A303 Amesbury to Berwick Down

**8.3 (2) – Statement of Common Ground– Historic Buildings and
Monuments Commission for England**

**STATEMENT OF COMMON GROUND – Historic Buildings and Monuments
Commission for England**

Regulation Number:	Regulation 5(2)(q)
Planning Inspectorate Scheme Reference	TR010025
Application Document Reference	8.3 (2)
Author:	A303 Project Team, Highways England, and Historic England

Highways England Project Office
Temple Quay House
2 The Square, Temple Quay
Bristol, BS1 6HA
Scale @ A1

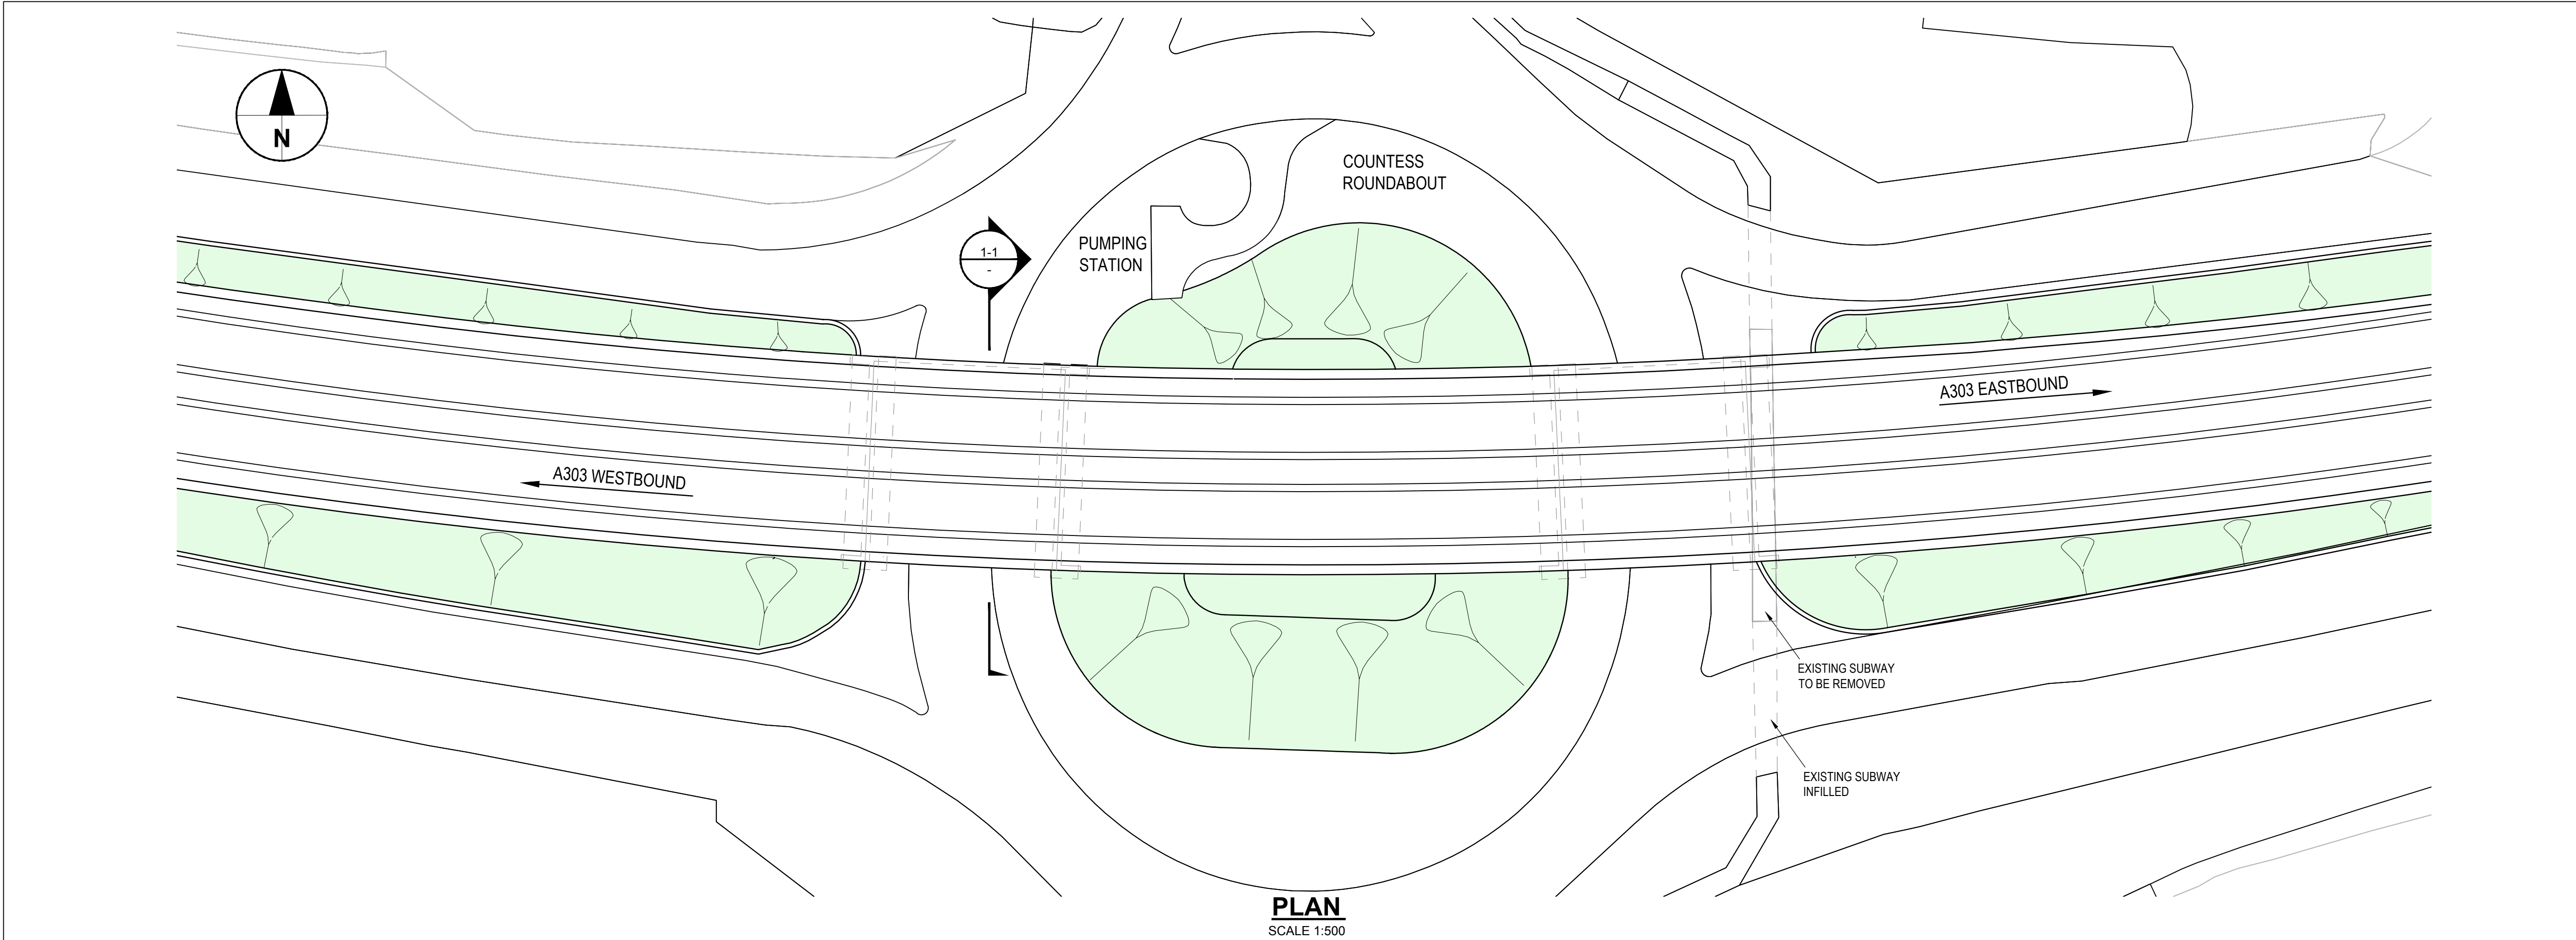
Issue Ref	Doc Ref	Paragraph Reference	Sub-section	HBMCE Comment	Highways England Response	Status
	[REP4-085]	Section 9.3, page 28	<p>visualisations</p> <p>Paragraph 9.2.1</p>	<p>representations for key elements of infrastructure within the WHS, including the western tunnel portal and its extension, the eastern tunnel portal, the articulation and form of open cutting retaining walls and the design, construction, form and appearance of Green Bridge 4.</p> <p>The Written summaries of oral submissions put at Issue Specific Hearings [REP4-85] confirmed that within the Written Representations HBMCE advised that it was essential that the complement of visualisations submitted demonstrated to the Examining Authority the full range of visual impacts on the OUV and experience of the Stonehenge WHS and the designated and non-designated heritage assets in that same landscape (Section 7.5.18). We welcome the further requests for additional visualisations from the Examining Authority, some of which were produced and submitted at Deadline 3.</p> <p>We are pleased to note that further visualisations have been submitted. However there remain some visualisations and design representations that we would like to</p>	<p>particular photomontages and CGI visualisations have been presented within the LVIA Chapter (Chapter 7 [APP-045]) and Cultural Heritage Chapters (Appendix 6.9 [APP-218]) of the ES. Design and visual representations will be developed through the detailed design process.</p> <p>The further detailed design of the portal and its associated infrastructure will be sensitive to its WHS context, following Highways England's guide 'The Road to Good Design' and will be developed in consultation with HBMCE. The OEMP (the final version of which was submitted at deadline 9) [REP9-013] has been updated in consultation with HBMCE to include a vision and design principles section and process for consultation in the development of detailed design including specific design principles relating to the portal and its associated infrastructure.</p> <p>It should be noted that the photomontages are based on the Environmental Masterplan [APP-</p>	Highways England that the issues that HBMCE has raised have been broadly addressed
